# LSC Responses to EPC Deviation Redlines

**DEVIATION No. 1 – Intersection Spacing (Rev. 11/17/2023; 6/2/2023; Original 1/4/2020):** A deviation from the standards of or in Sections **2.2.5.D** and **2.3.2** of the Engineering Criteria Manual (ECM) is requested. The request is for – **Part 1a:** a full-movement, roundabout intersection on a proposed Non-Residential Collector street 580 feet south of the Woodmen Road/US Highway 24 intersection (centerline spacing – estimated, following widening of US Highway 24 to four lanes). **Part 1b:** a three-quarter-movement intersection (access to commercial lots- Willet Way) on a proposed Non-Residential Collector street 235 feet west of the Retail Row Street/Rio Lane intersection (centerline spacing).

Commons at Falcon Field (LSC# 234220)

Deviation Exhibit 2a-2

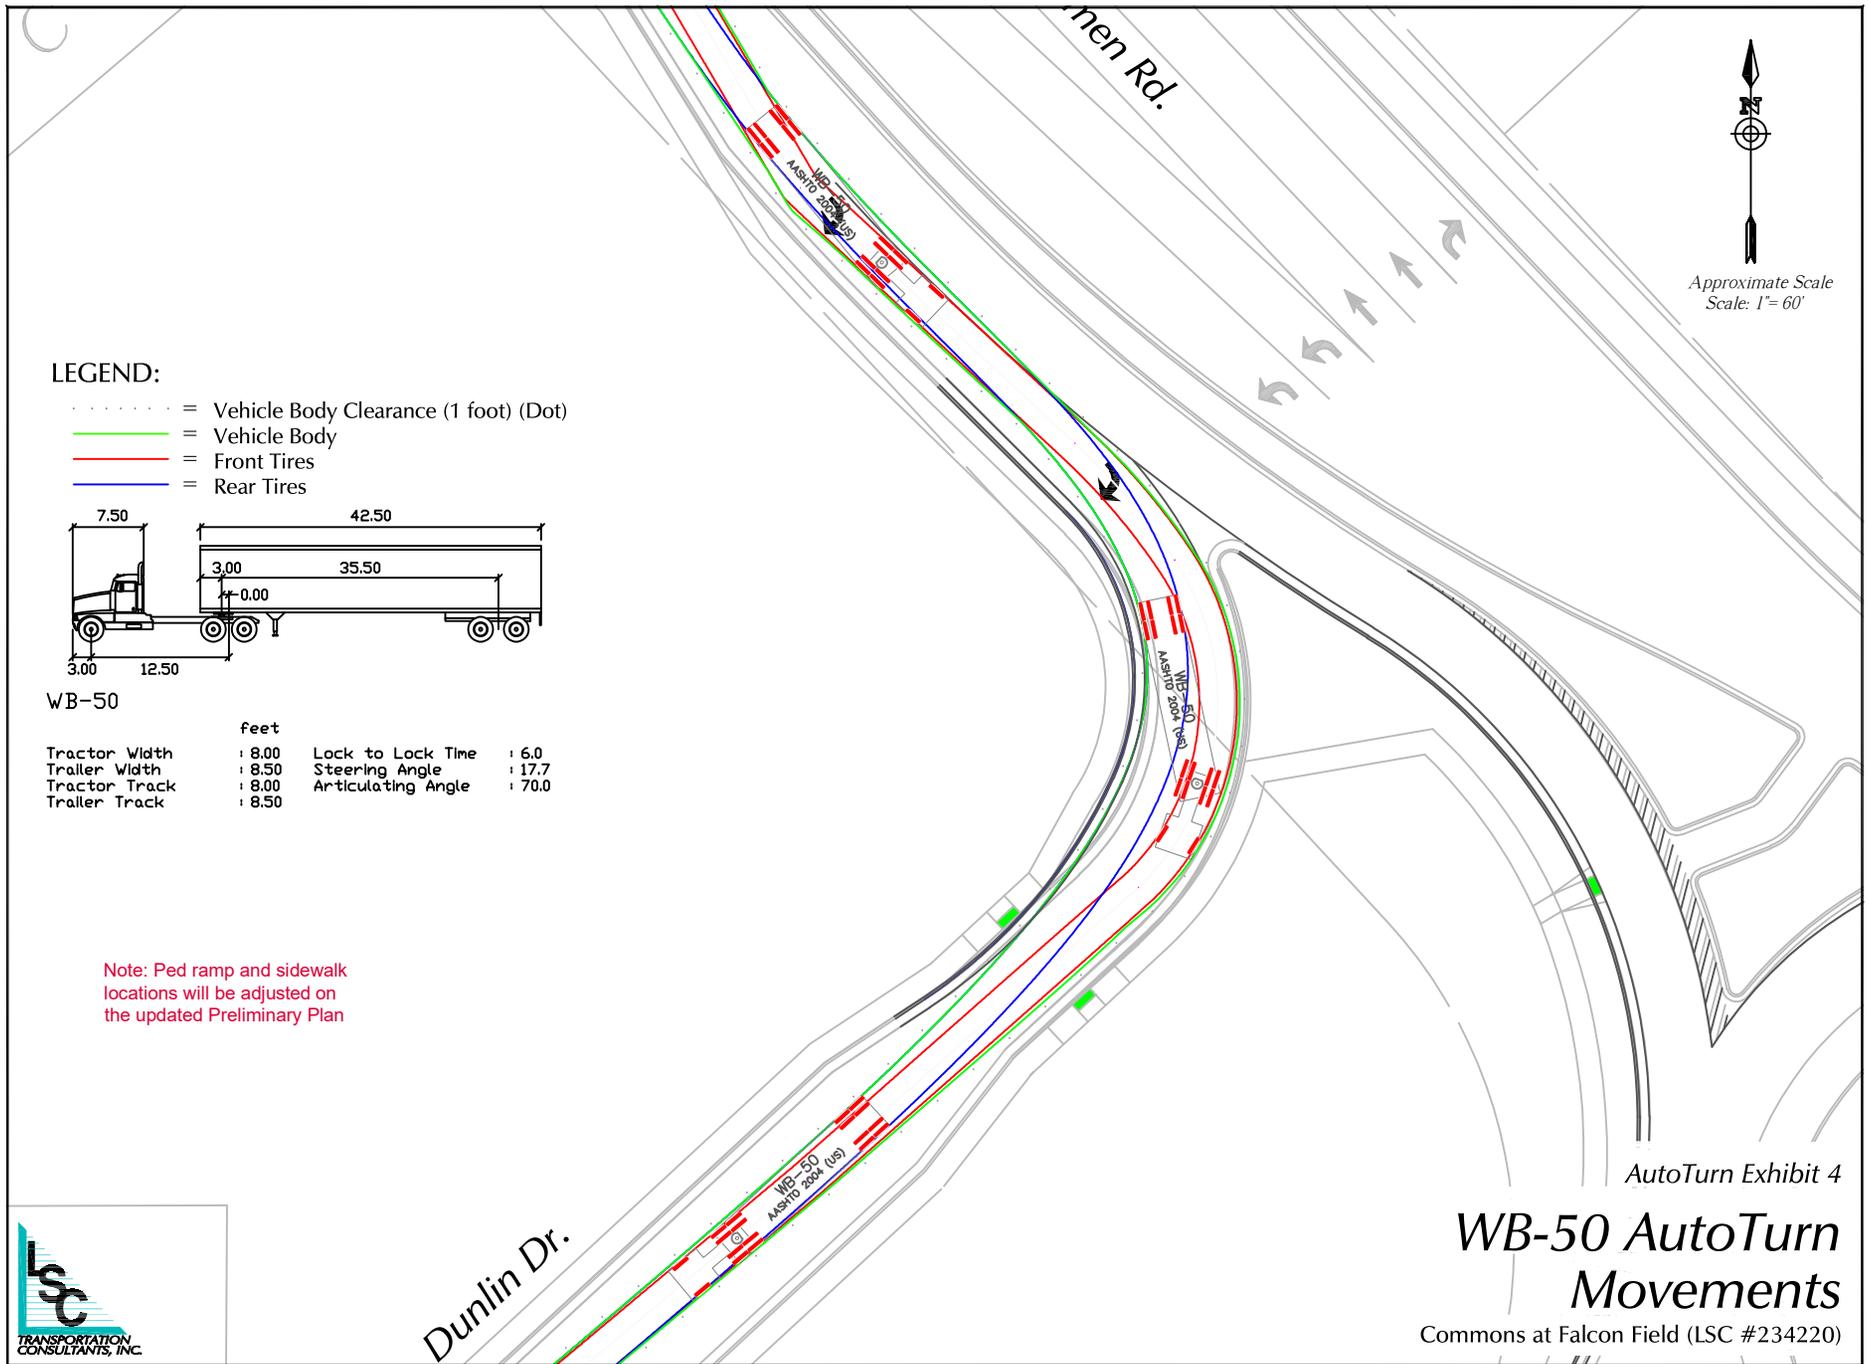
US-24  
Colors are missing

Colors are missing

Author: jchodsdon    Subject: Sticky Note    Date: 2/9/2024 11:48:34 AM  
LSC Response: Corrected.
